Application no: H14/0567/00

Description: Proposed dwelling and garage
to replace store building

Location: Land adj. 29 Horsepit Lane
Pinchbeck
Spalding
Lincolnshire

NOTICE OF ACCEPTANCE OF AMENDMENT

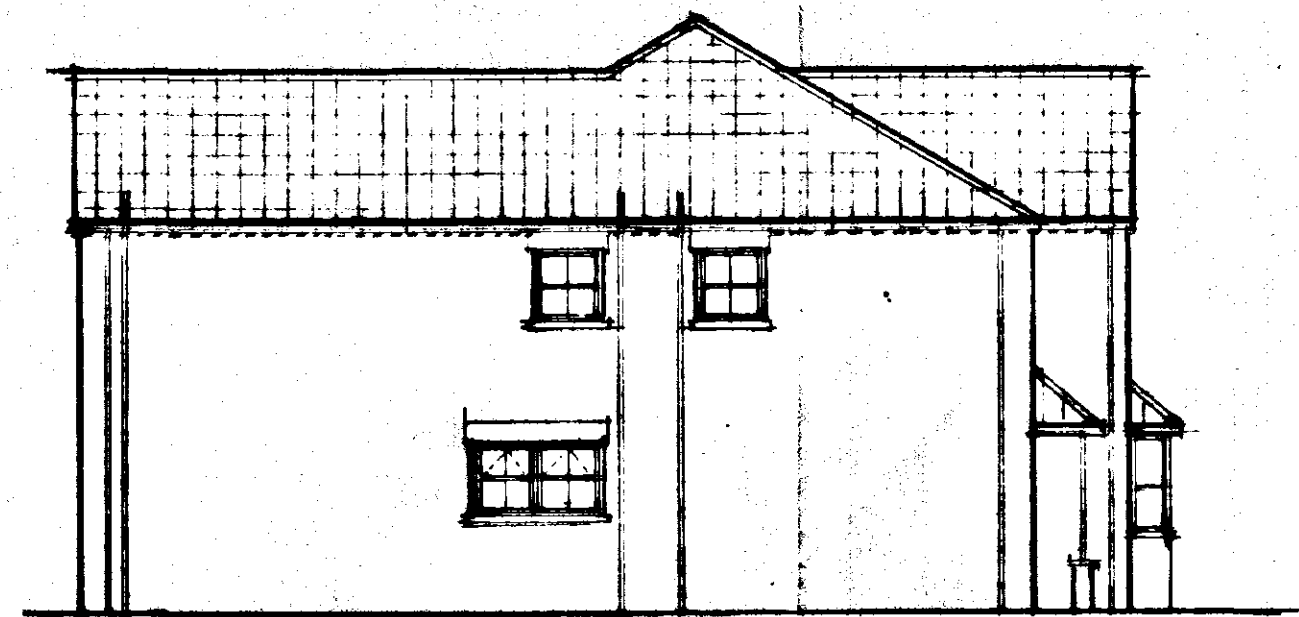
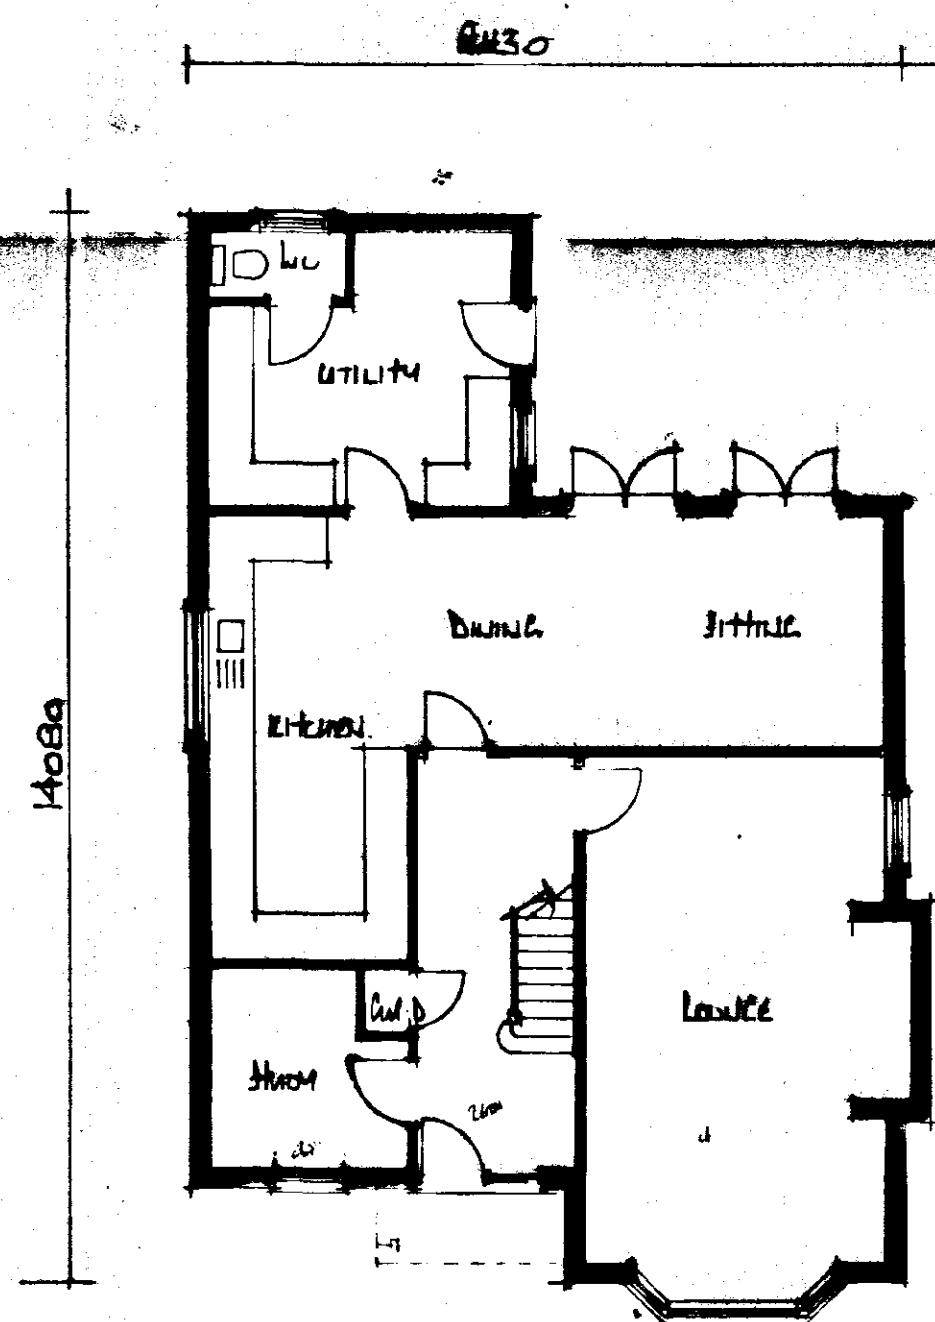
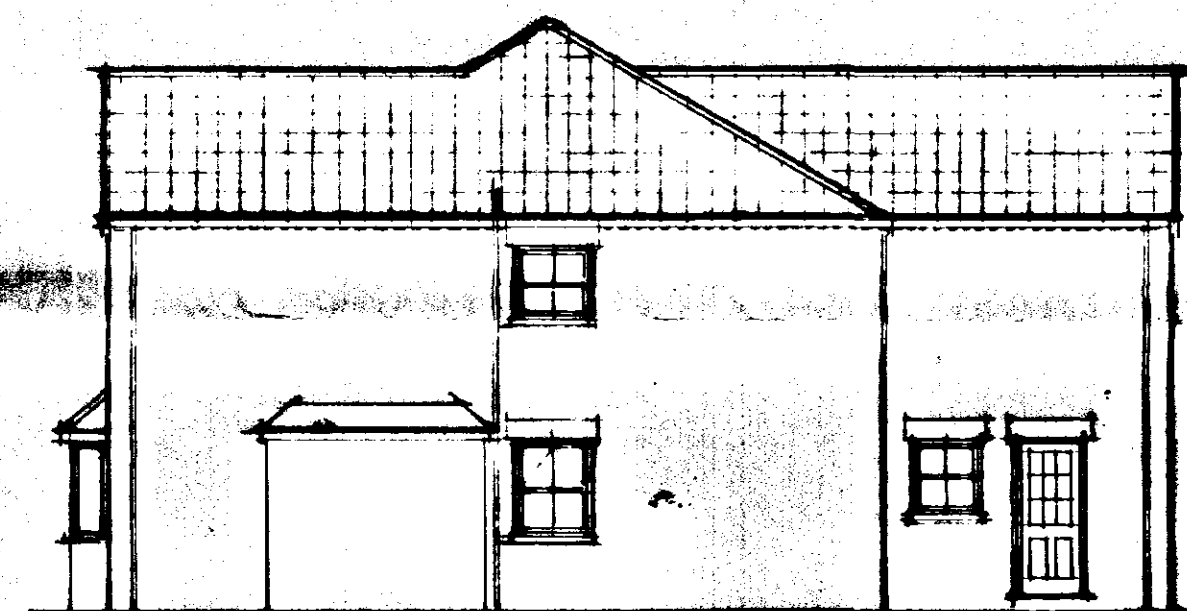
Amendment: Herringbone brickwork removed from north elevation.
Entrance frame to front door altered. WC window reduced

HERRINGBONE BRICKWORK REMOVED FROM NORTH ELEVATION
ENTRANCE FRAME TO FRONT DOOR ALTERED
N.W. WINDOW REDUCED IN WIDTH. (SOUTH ELEVATION)

The amended details submitted in respect of the above proposal have now been considered and there are no objections to the amendment being implemented to the extent described above.

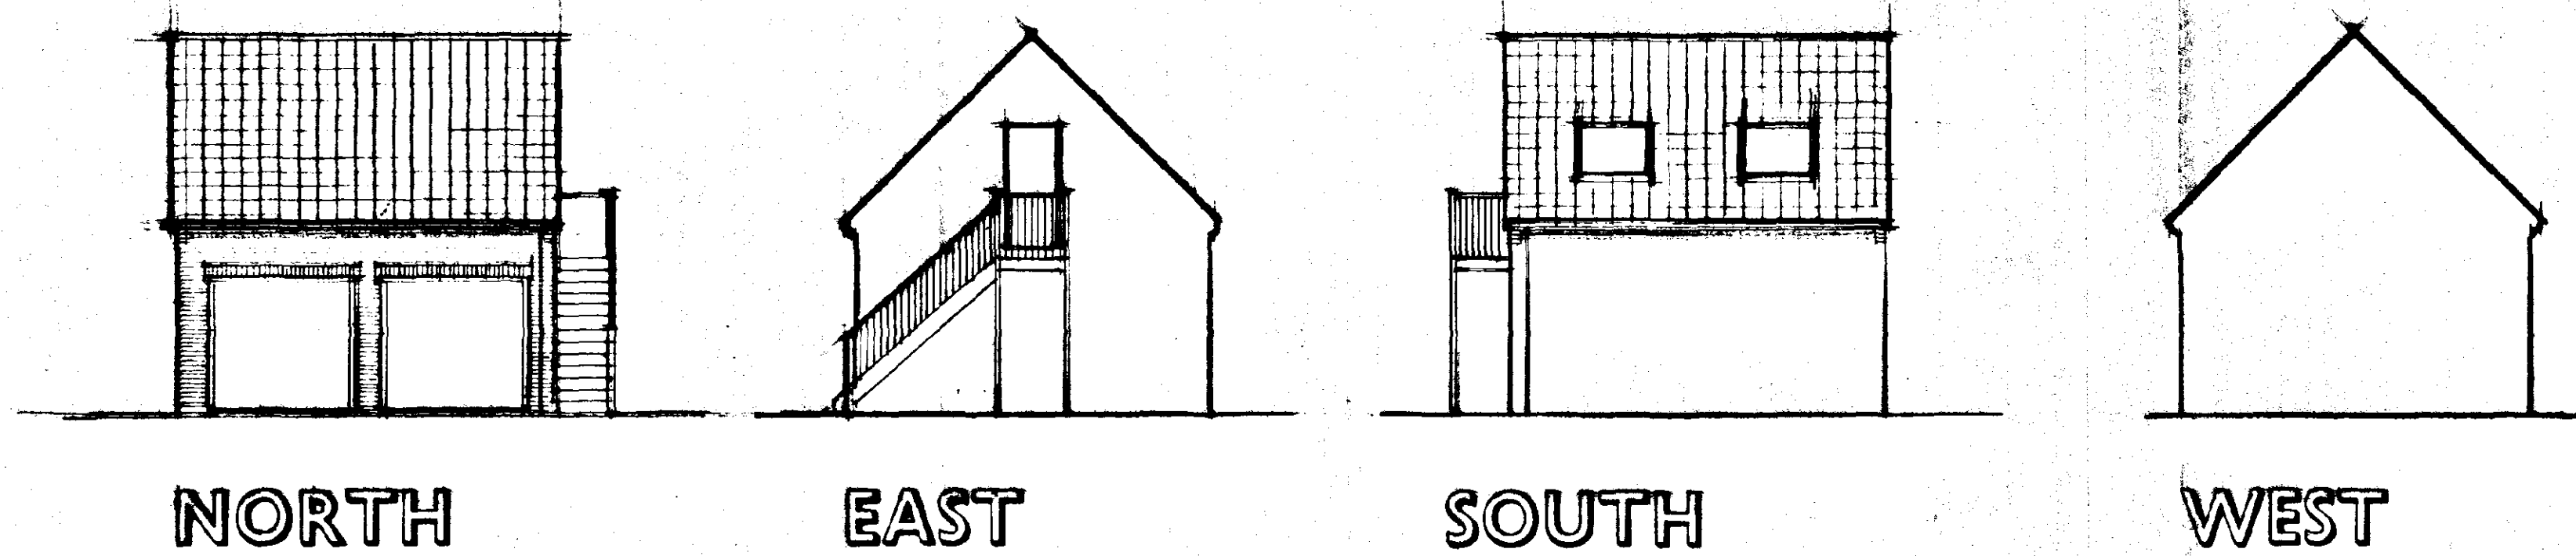
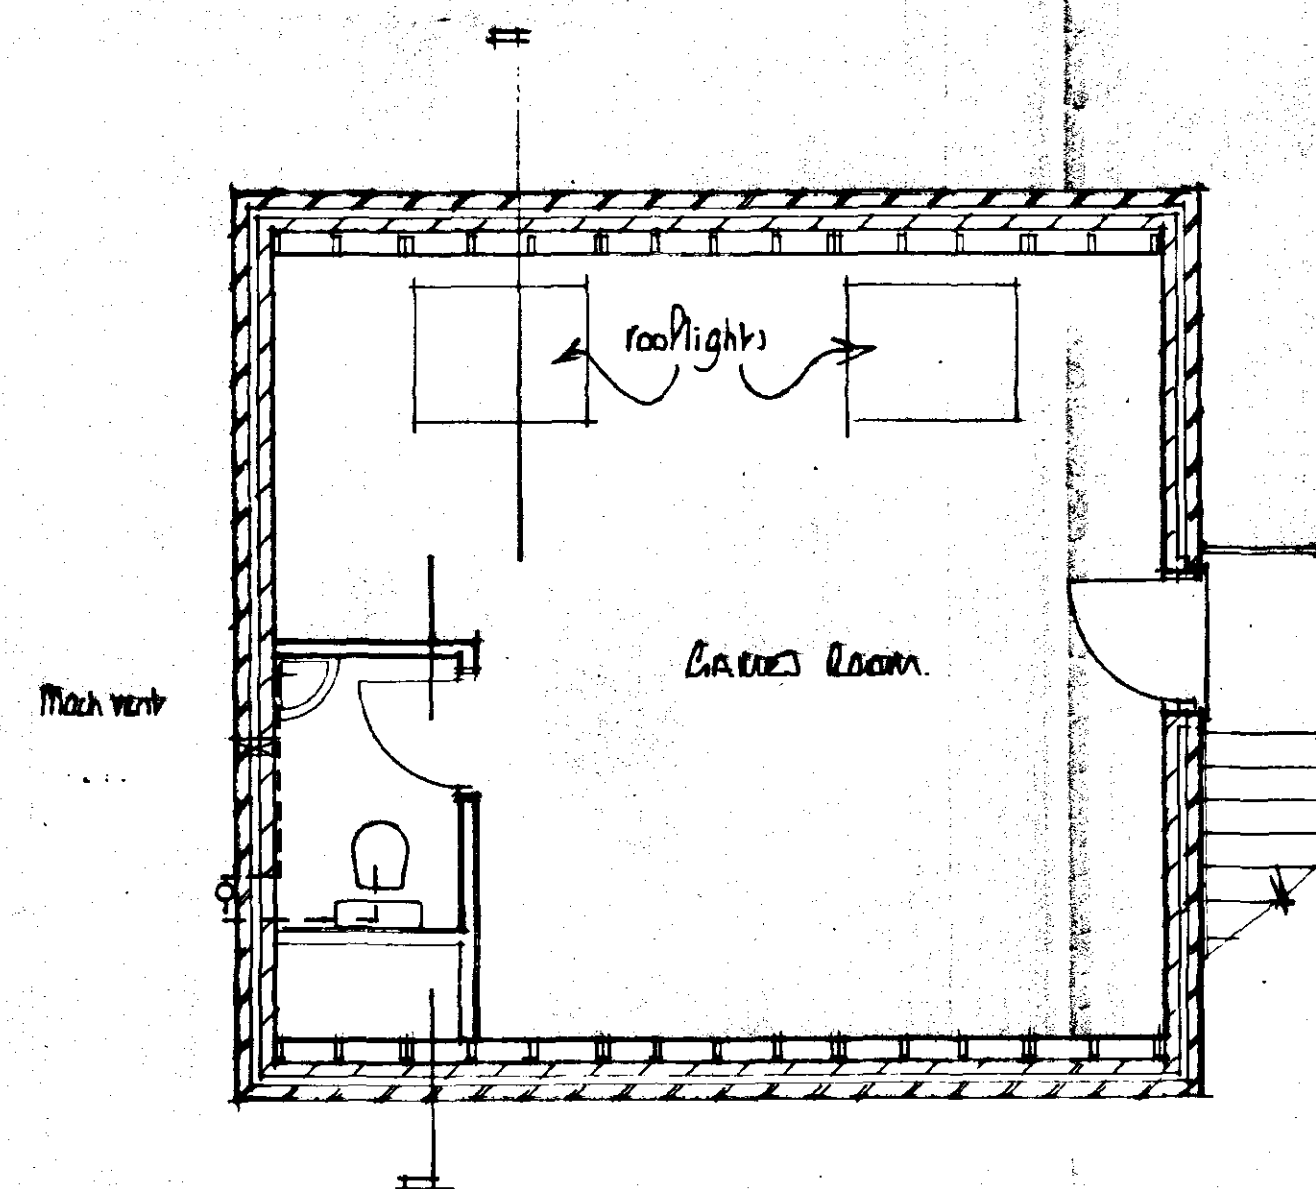
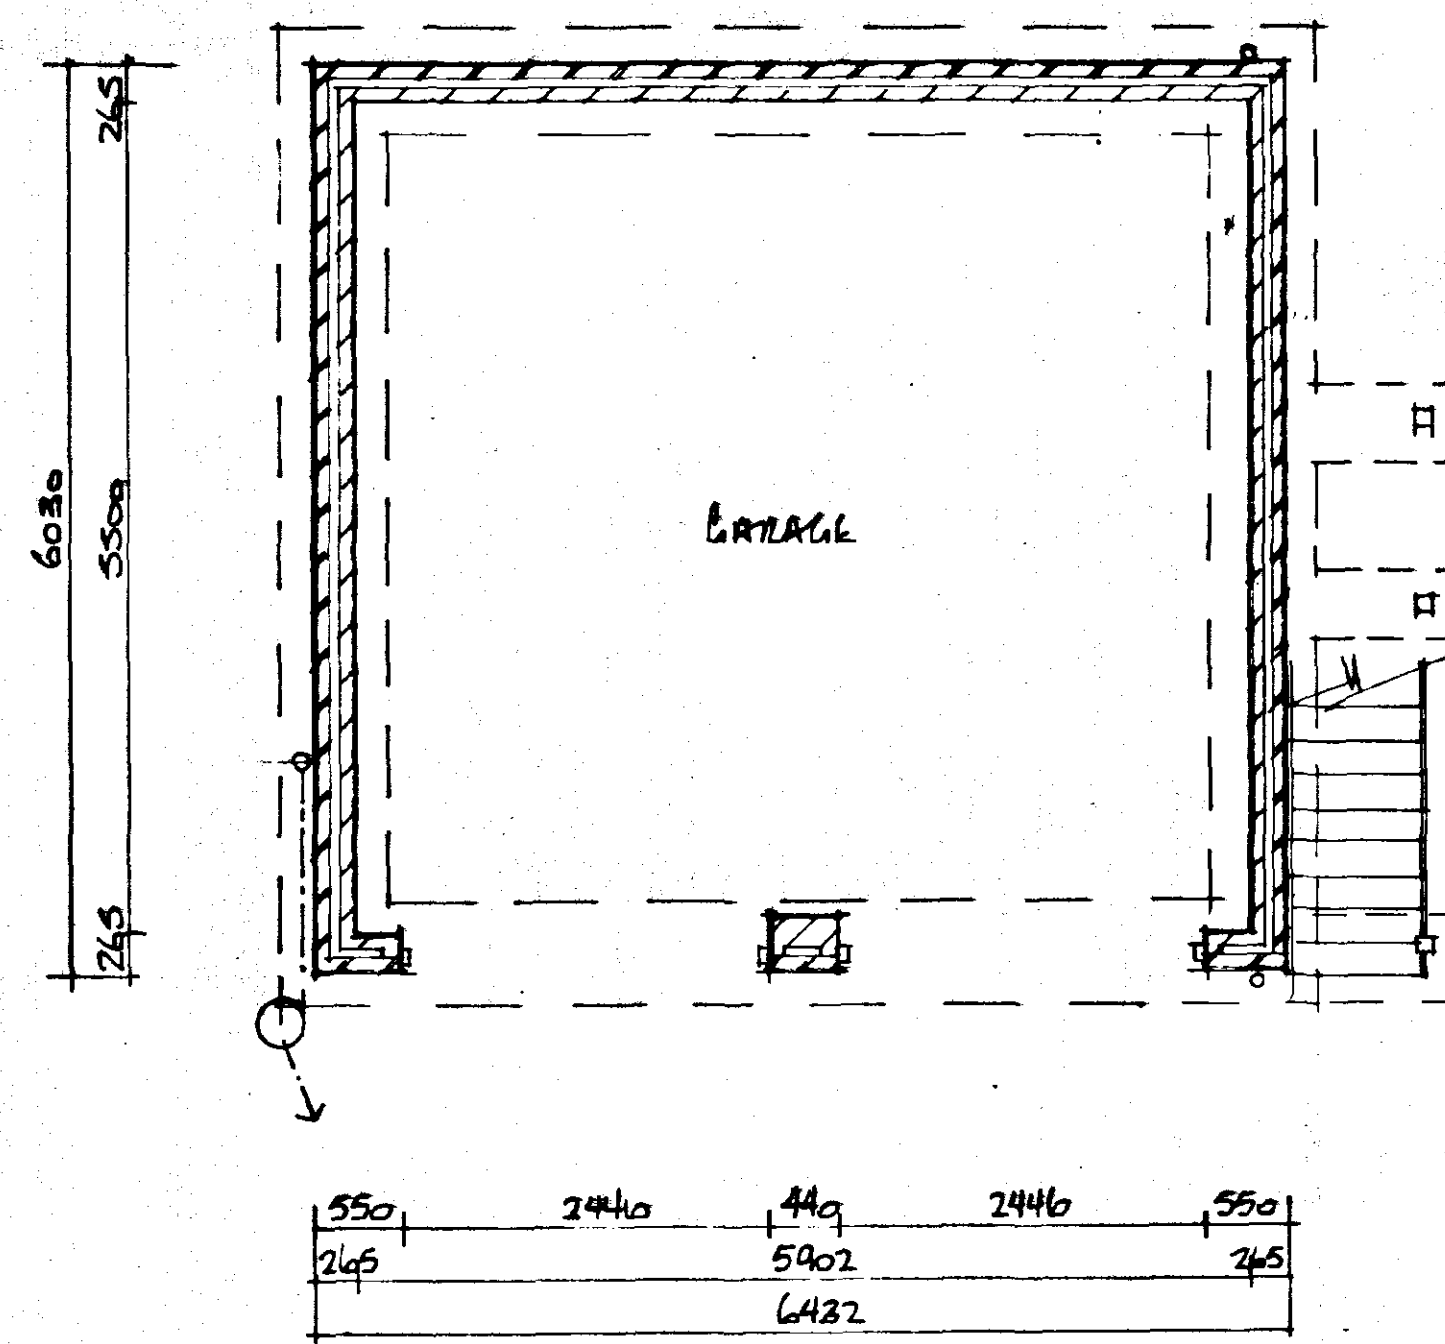
Amendment: Garage amended to include first floor games room
Dwg. No. 00/16/05 & 00/16/02

GARAGE AMENDED to INCLUDE FIRST FLOOR
GARAGE ROOM

The amended details submitted in respect of the above proposal have been received and I consider that the changes are too significant to be treated merely as a amendment. A fresh application will therefore be required (forms enclosed). This does not imply that premission will or will not be forthcoming for any such revised application.
